Appeal Decision

Appeal Ref: APP/T2350/W/23/3329857

107 Whalley Road, Read, Lancashire BB12 7RP

- The application Ref 3/2023/0464, dated 8 June 2023, was approved on 7 August 2023 and planning permission was granted subject to conditions.
 - The development permitted is a single-storey extension to rear with balcony to first floor and alterations to first floor rear windows.

SHEET:
PROPOSED ELEVATIONS 2

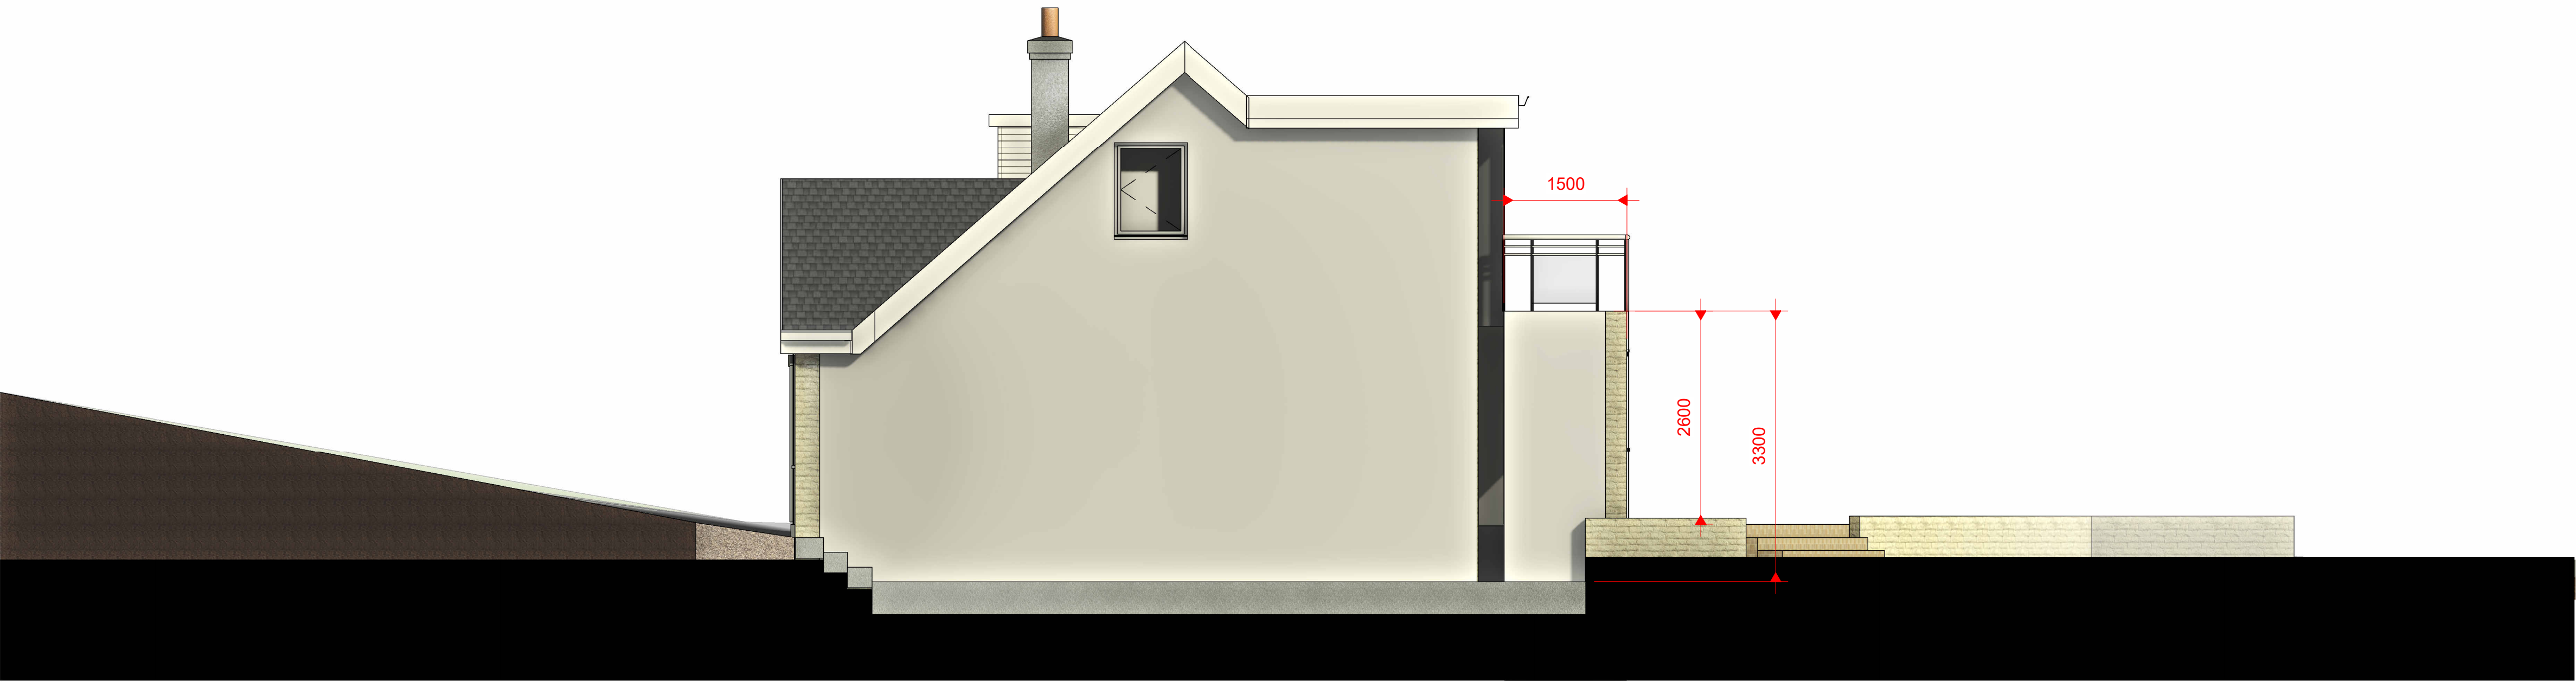
15. Whilst the submitted plans indicate provision of a 1.8 metre high, obscure glazed privacy screen at either end of the proposed balcony, this is not supported by any details of the glazing or level of obscurity to be used. Consequently, I therefore find that a condition requiring the submission and approval of the details of the glazing to be used and prohibiting the use of the balcony until the approved screen has been constructed and retained thereafter is necessary to ensure that the living conditions of the occupiers of neighbouring properties are protected.

1. The appeal is allowed and the planning permission Ref 3/2023/0464 for a single-storey extension to rear with balcony to first floor and alterations to first floor rear windows at 107 Whalley Road, Read, Lancashire BB12 7RP granted on 7 August 2023 by Ribble Valley Borough Council, is varied by deleting condition no.4 and substituting it for the following condition:
 4. Notwithstanding the details shown on the approved plans, the balcony hereby permitted shall not be brought into use until obscure glazed privacy screens measuring 1.8m in height have been installed to the eastern and western (side) elevations. Details of the type of obscure glazed privacy screening to be used shall be submitted to and approved in writing by the local planning authority before it is installed and once installed the privacy screening shall be retained thereafter.

2 1 PROPOSED FIRST FLOOR  
1 : 50

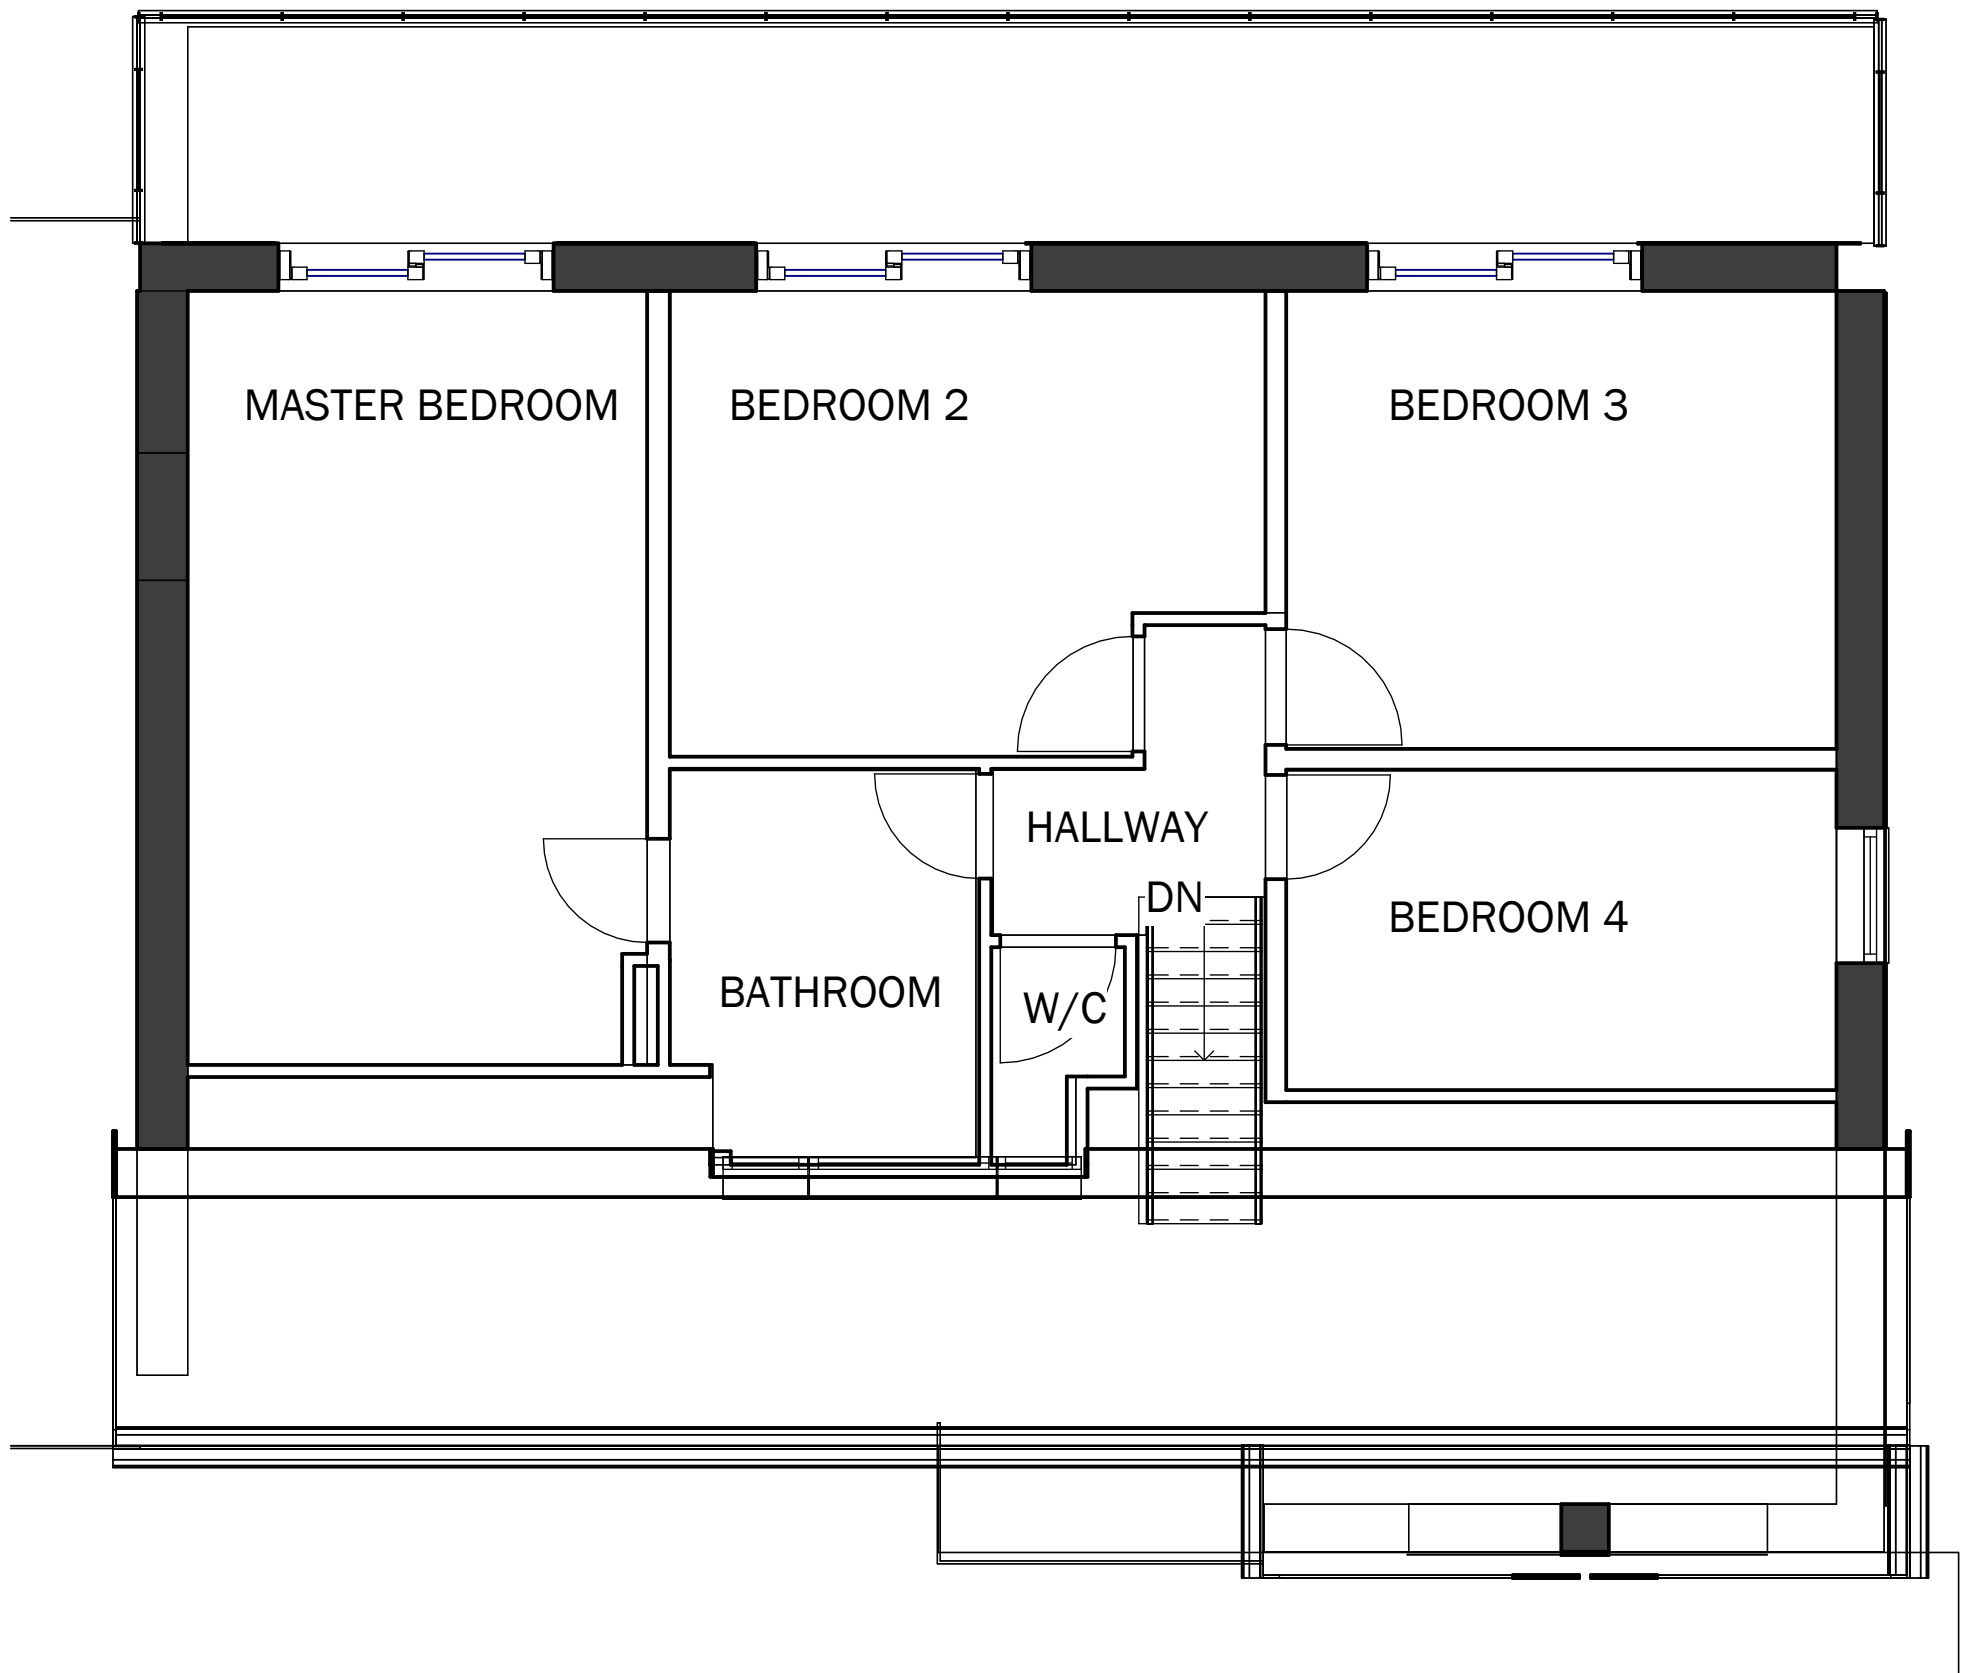
7. The proposed development would comprise a modest, single-storey rear extension, measuring approximately 1.5 metres in depth. The proposed balcony would be located above the extended part. However, it would not project beyond the rear walls of Nos. 105 and 109, with both of these properties extending further into their rear gardens than the appeal site. Although, I did observe side facing windows in both neighbouring properties, these would not be directly overlooked by the proposed balcony.

11. Notwithstanding this, the proposed development would nevertheless result in the creation of a raised platform, which can be used as a space to sit and enjoy and from which opportunities for overlooking, or the perception of being overlooked would be likely to increase. However, due to the limited size of the proposed balcony, measuring approximately 1.5 metres in depth, the ability to stand or sit a little further forward, would not significantly change the degree of overlooking into neighbouring gardens.
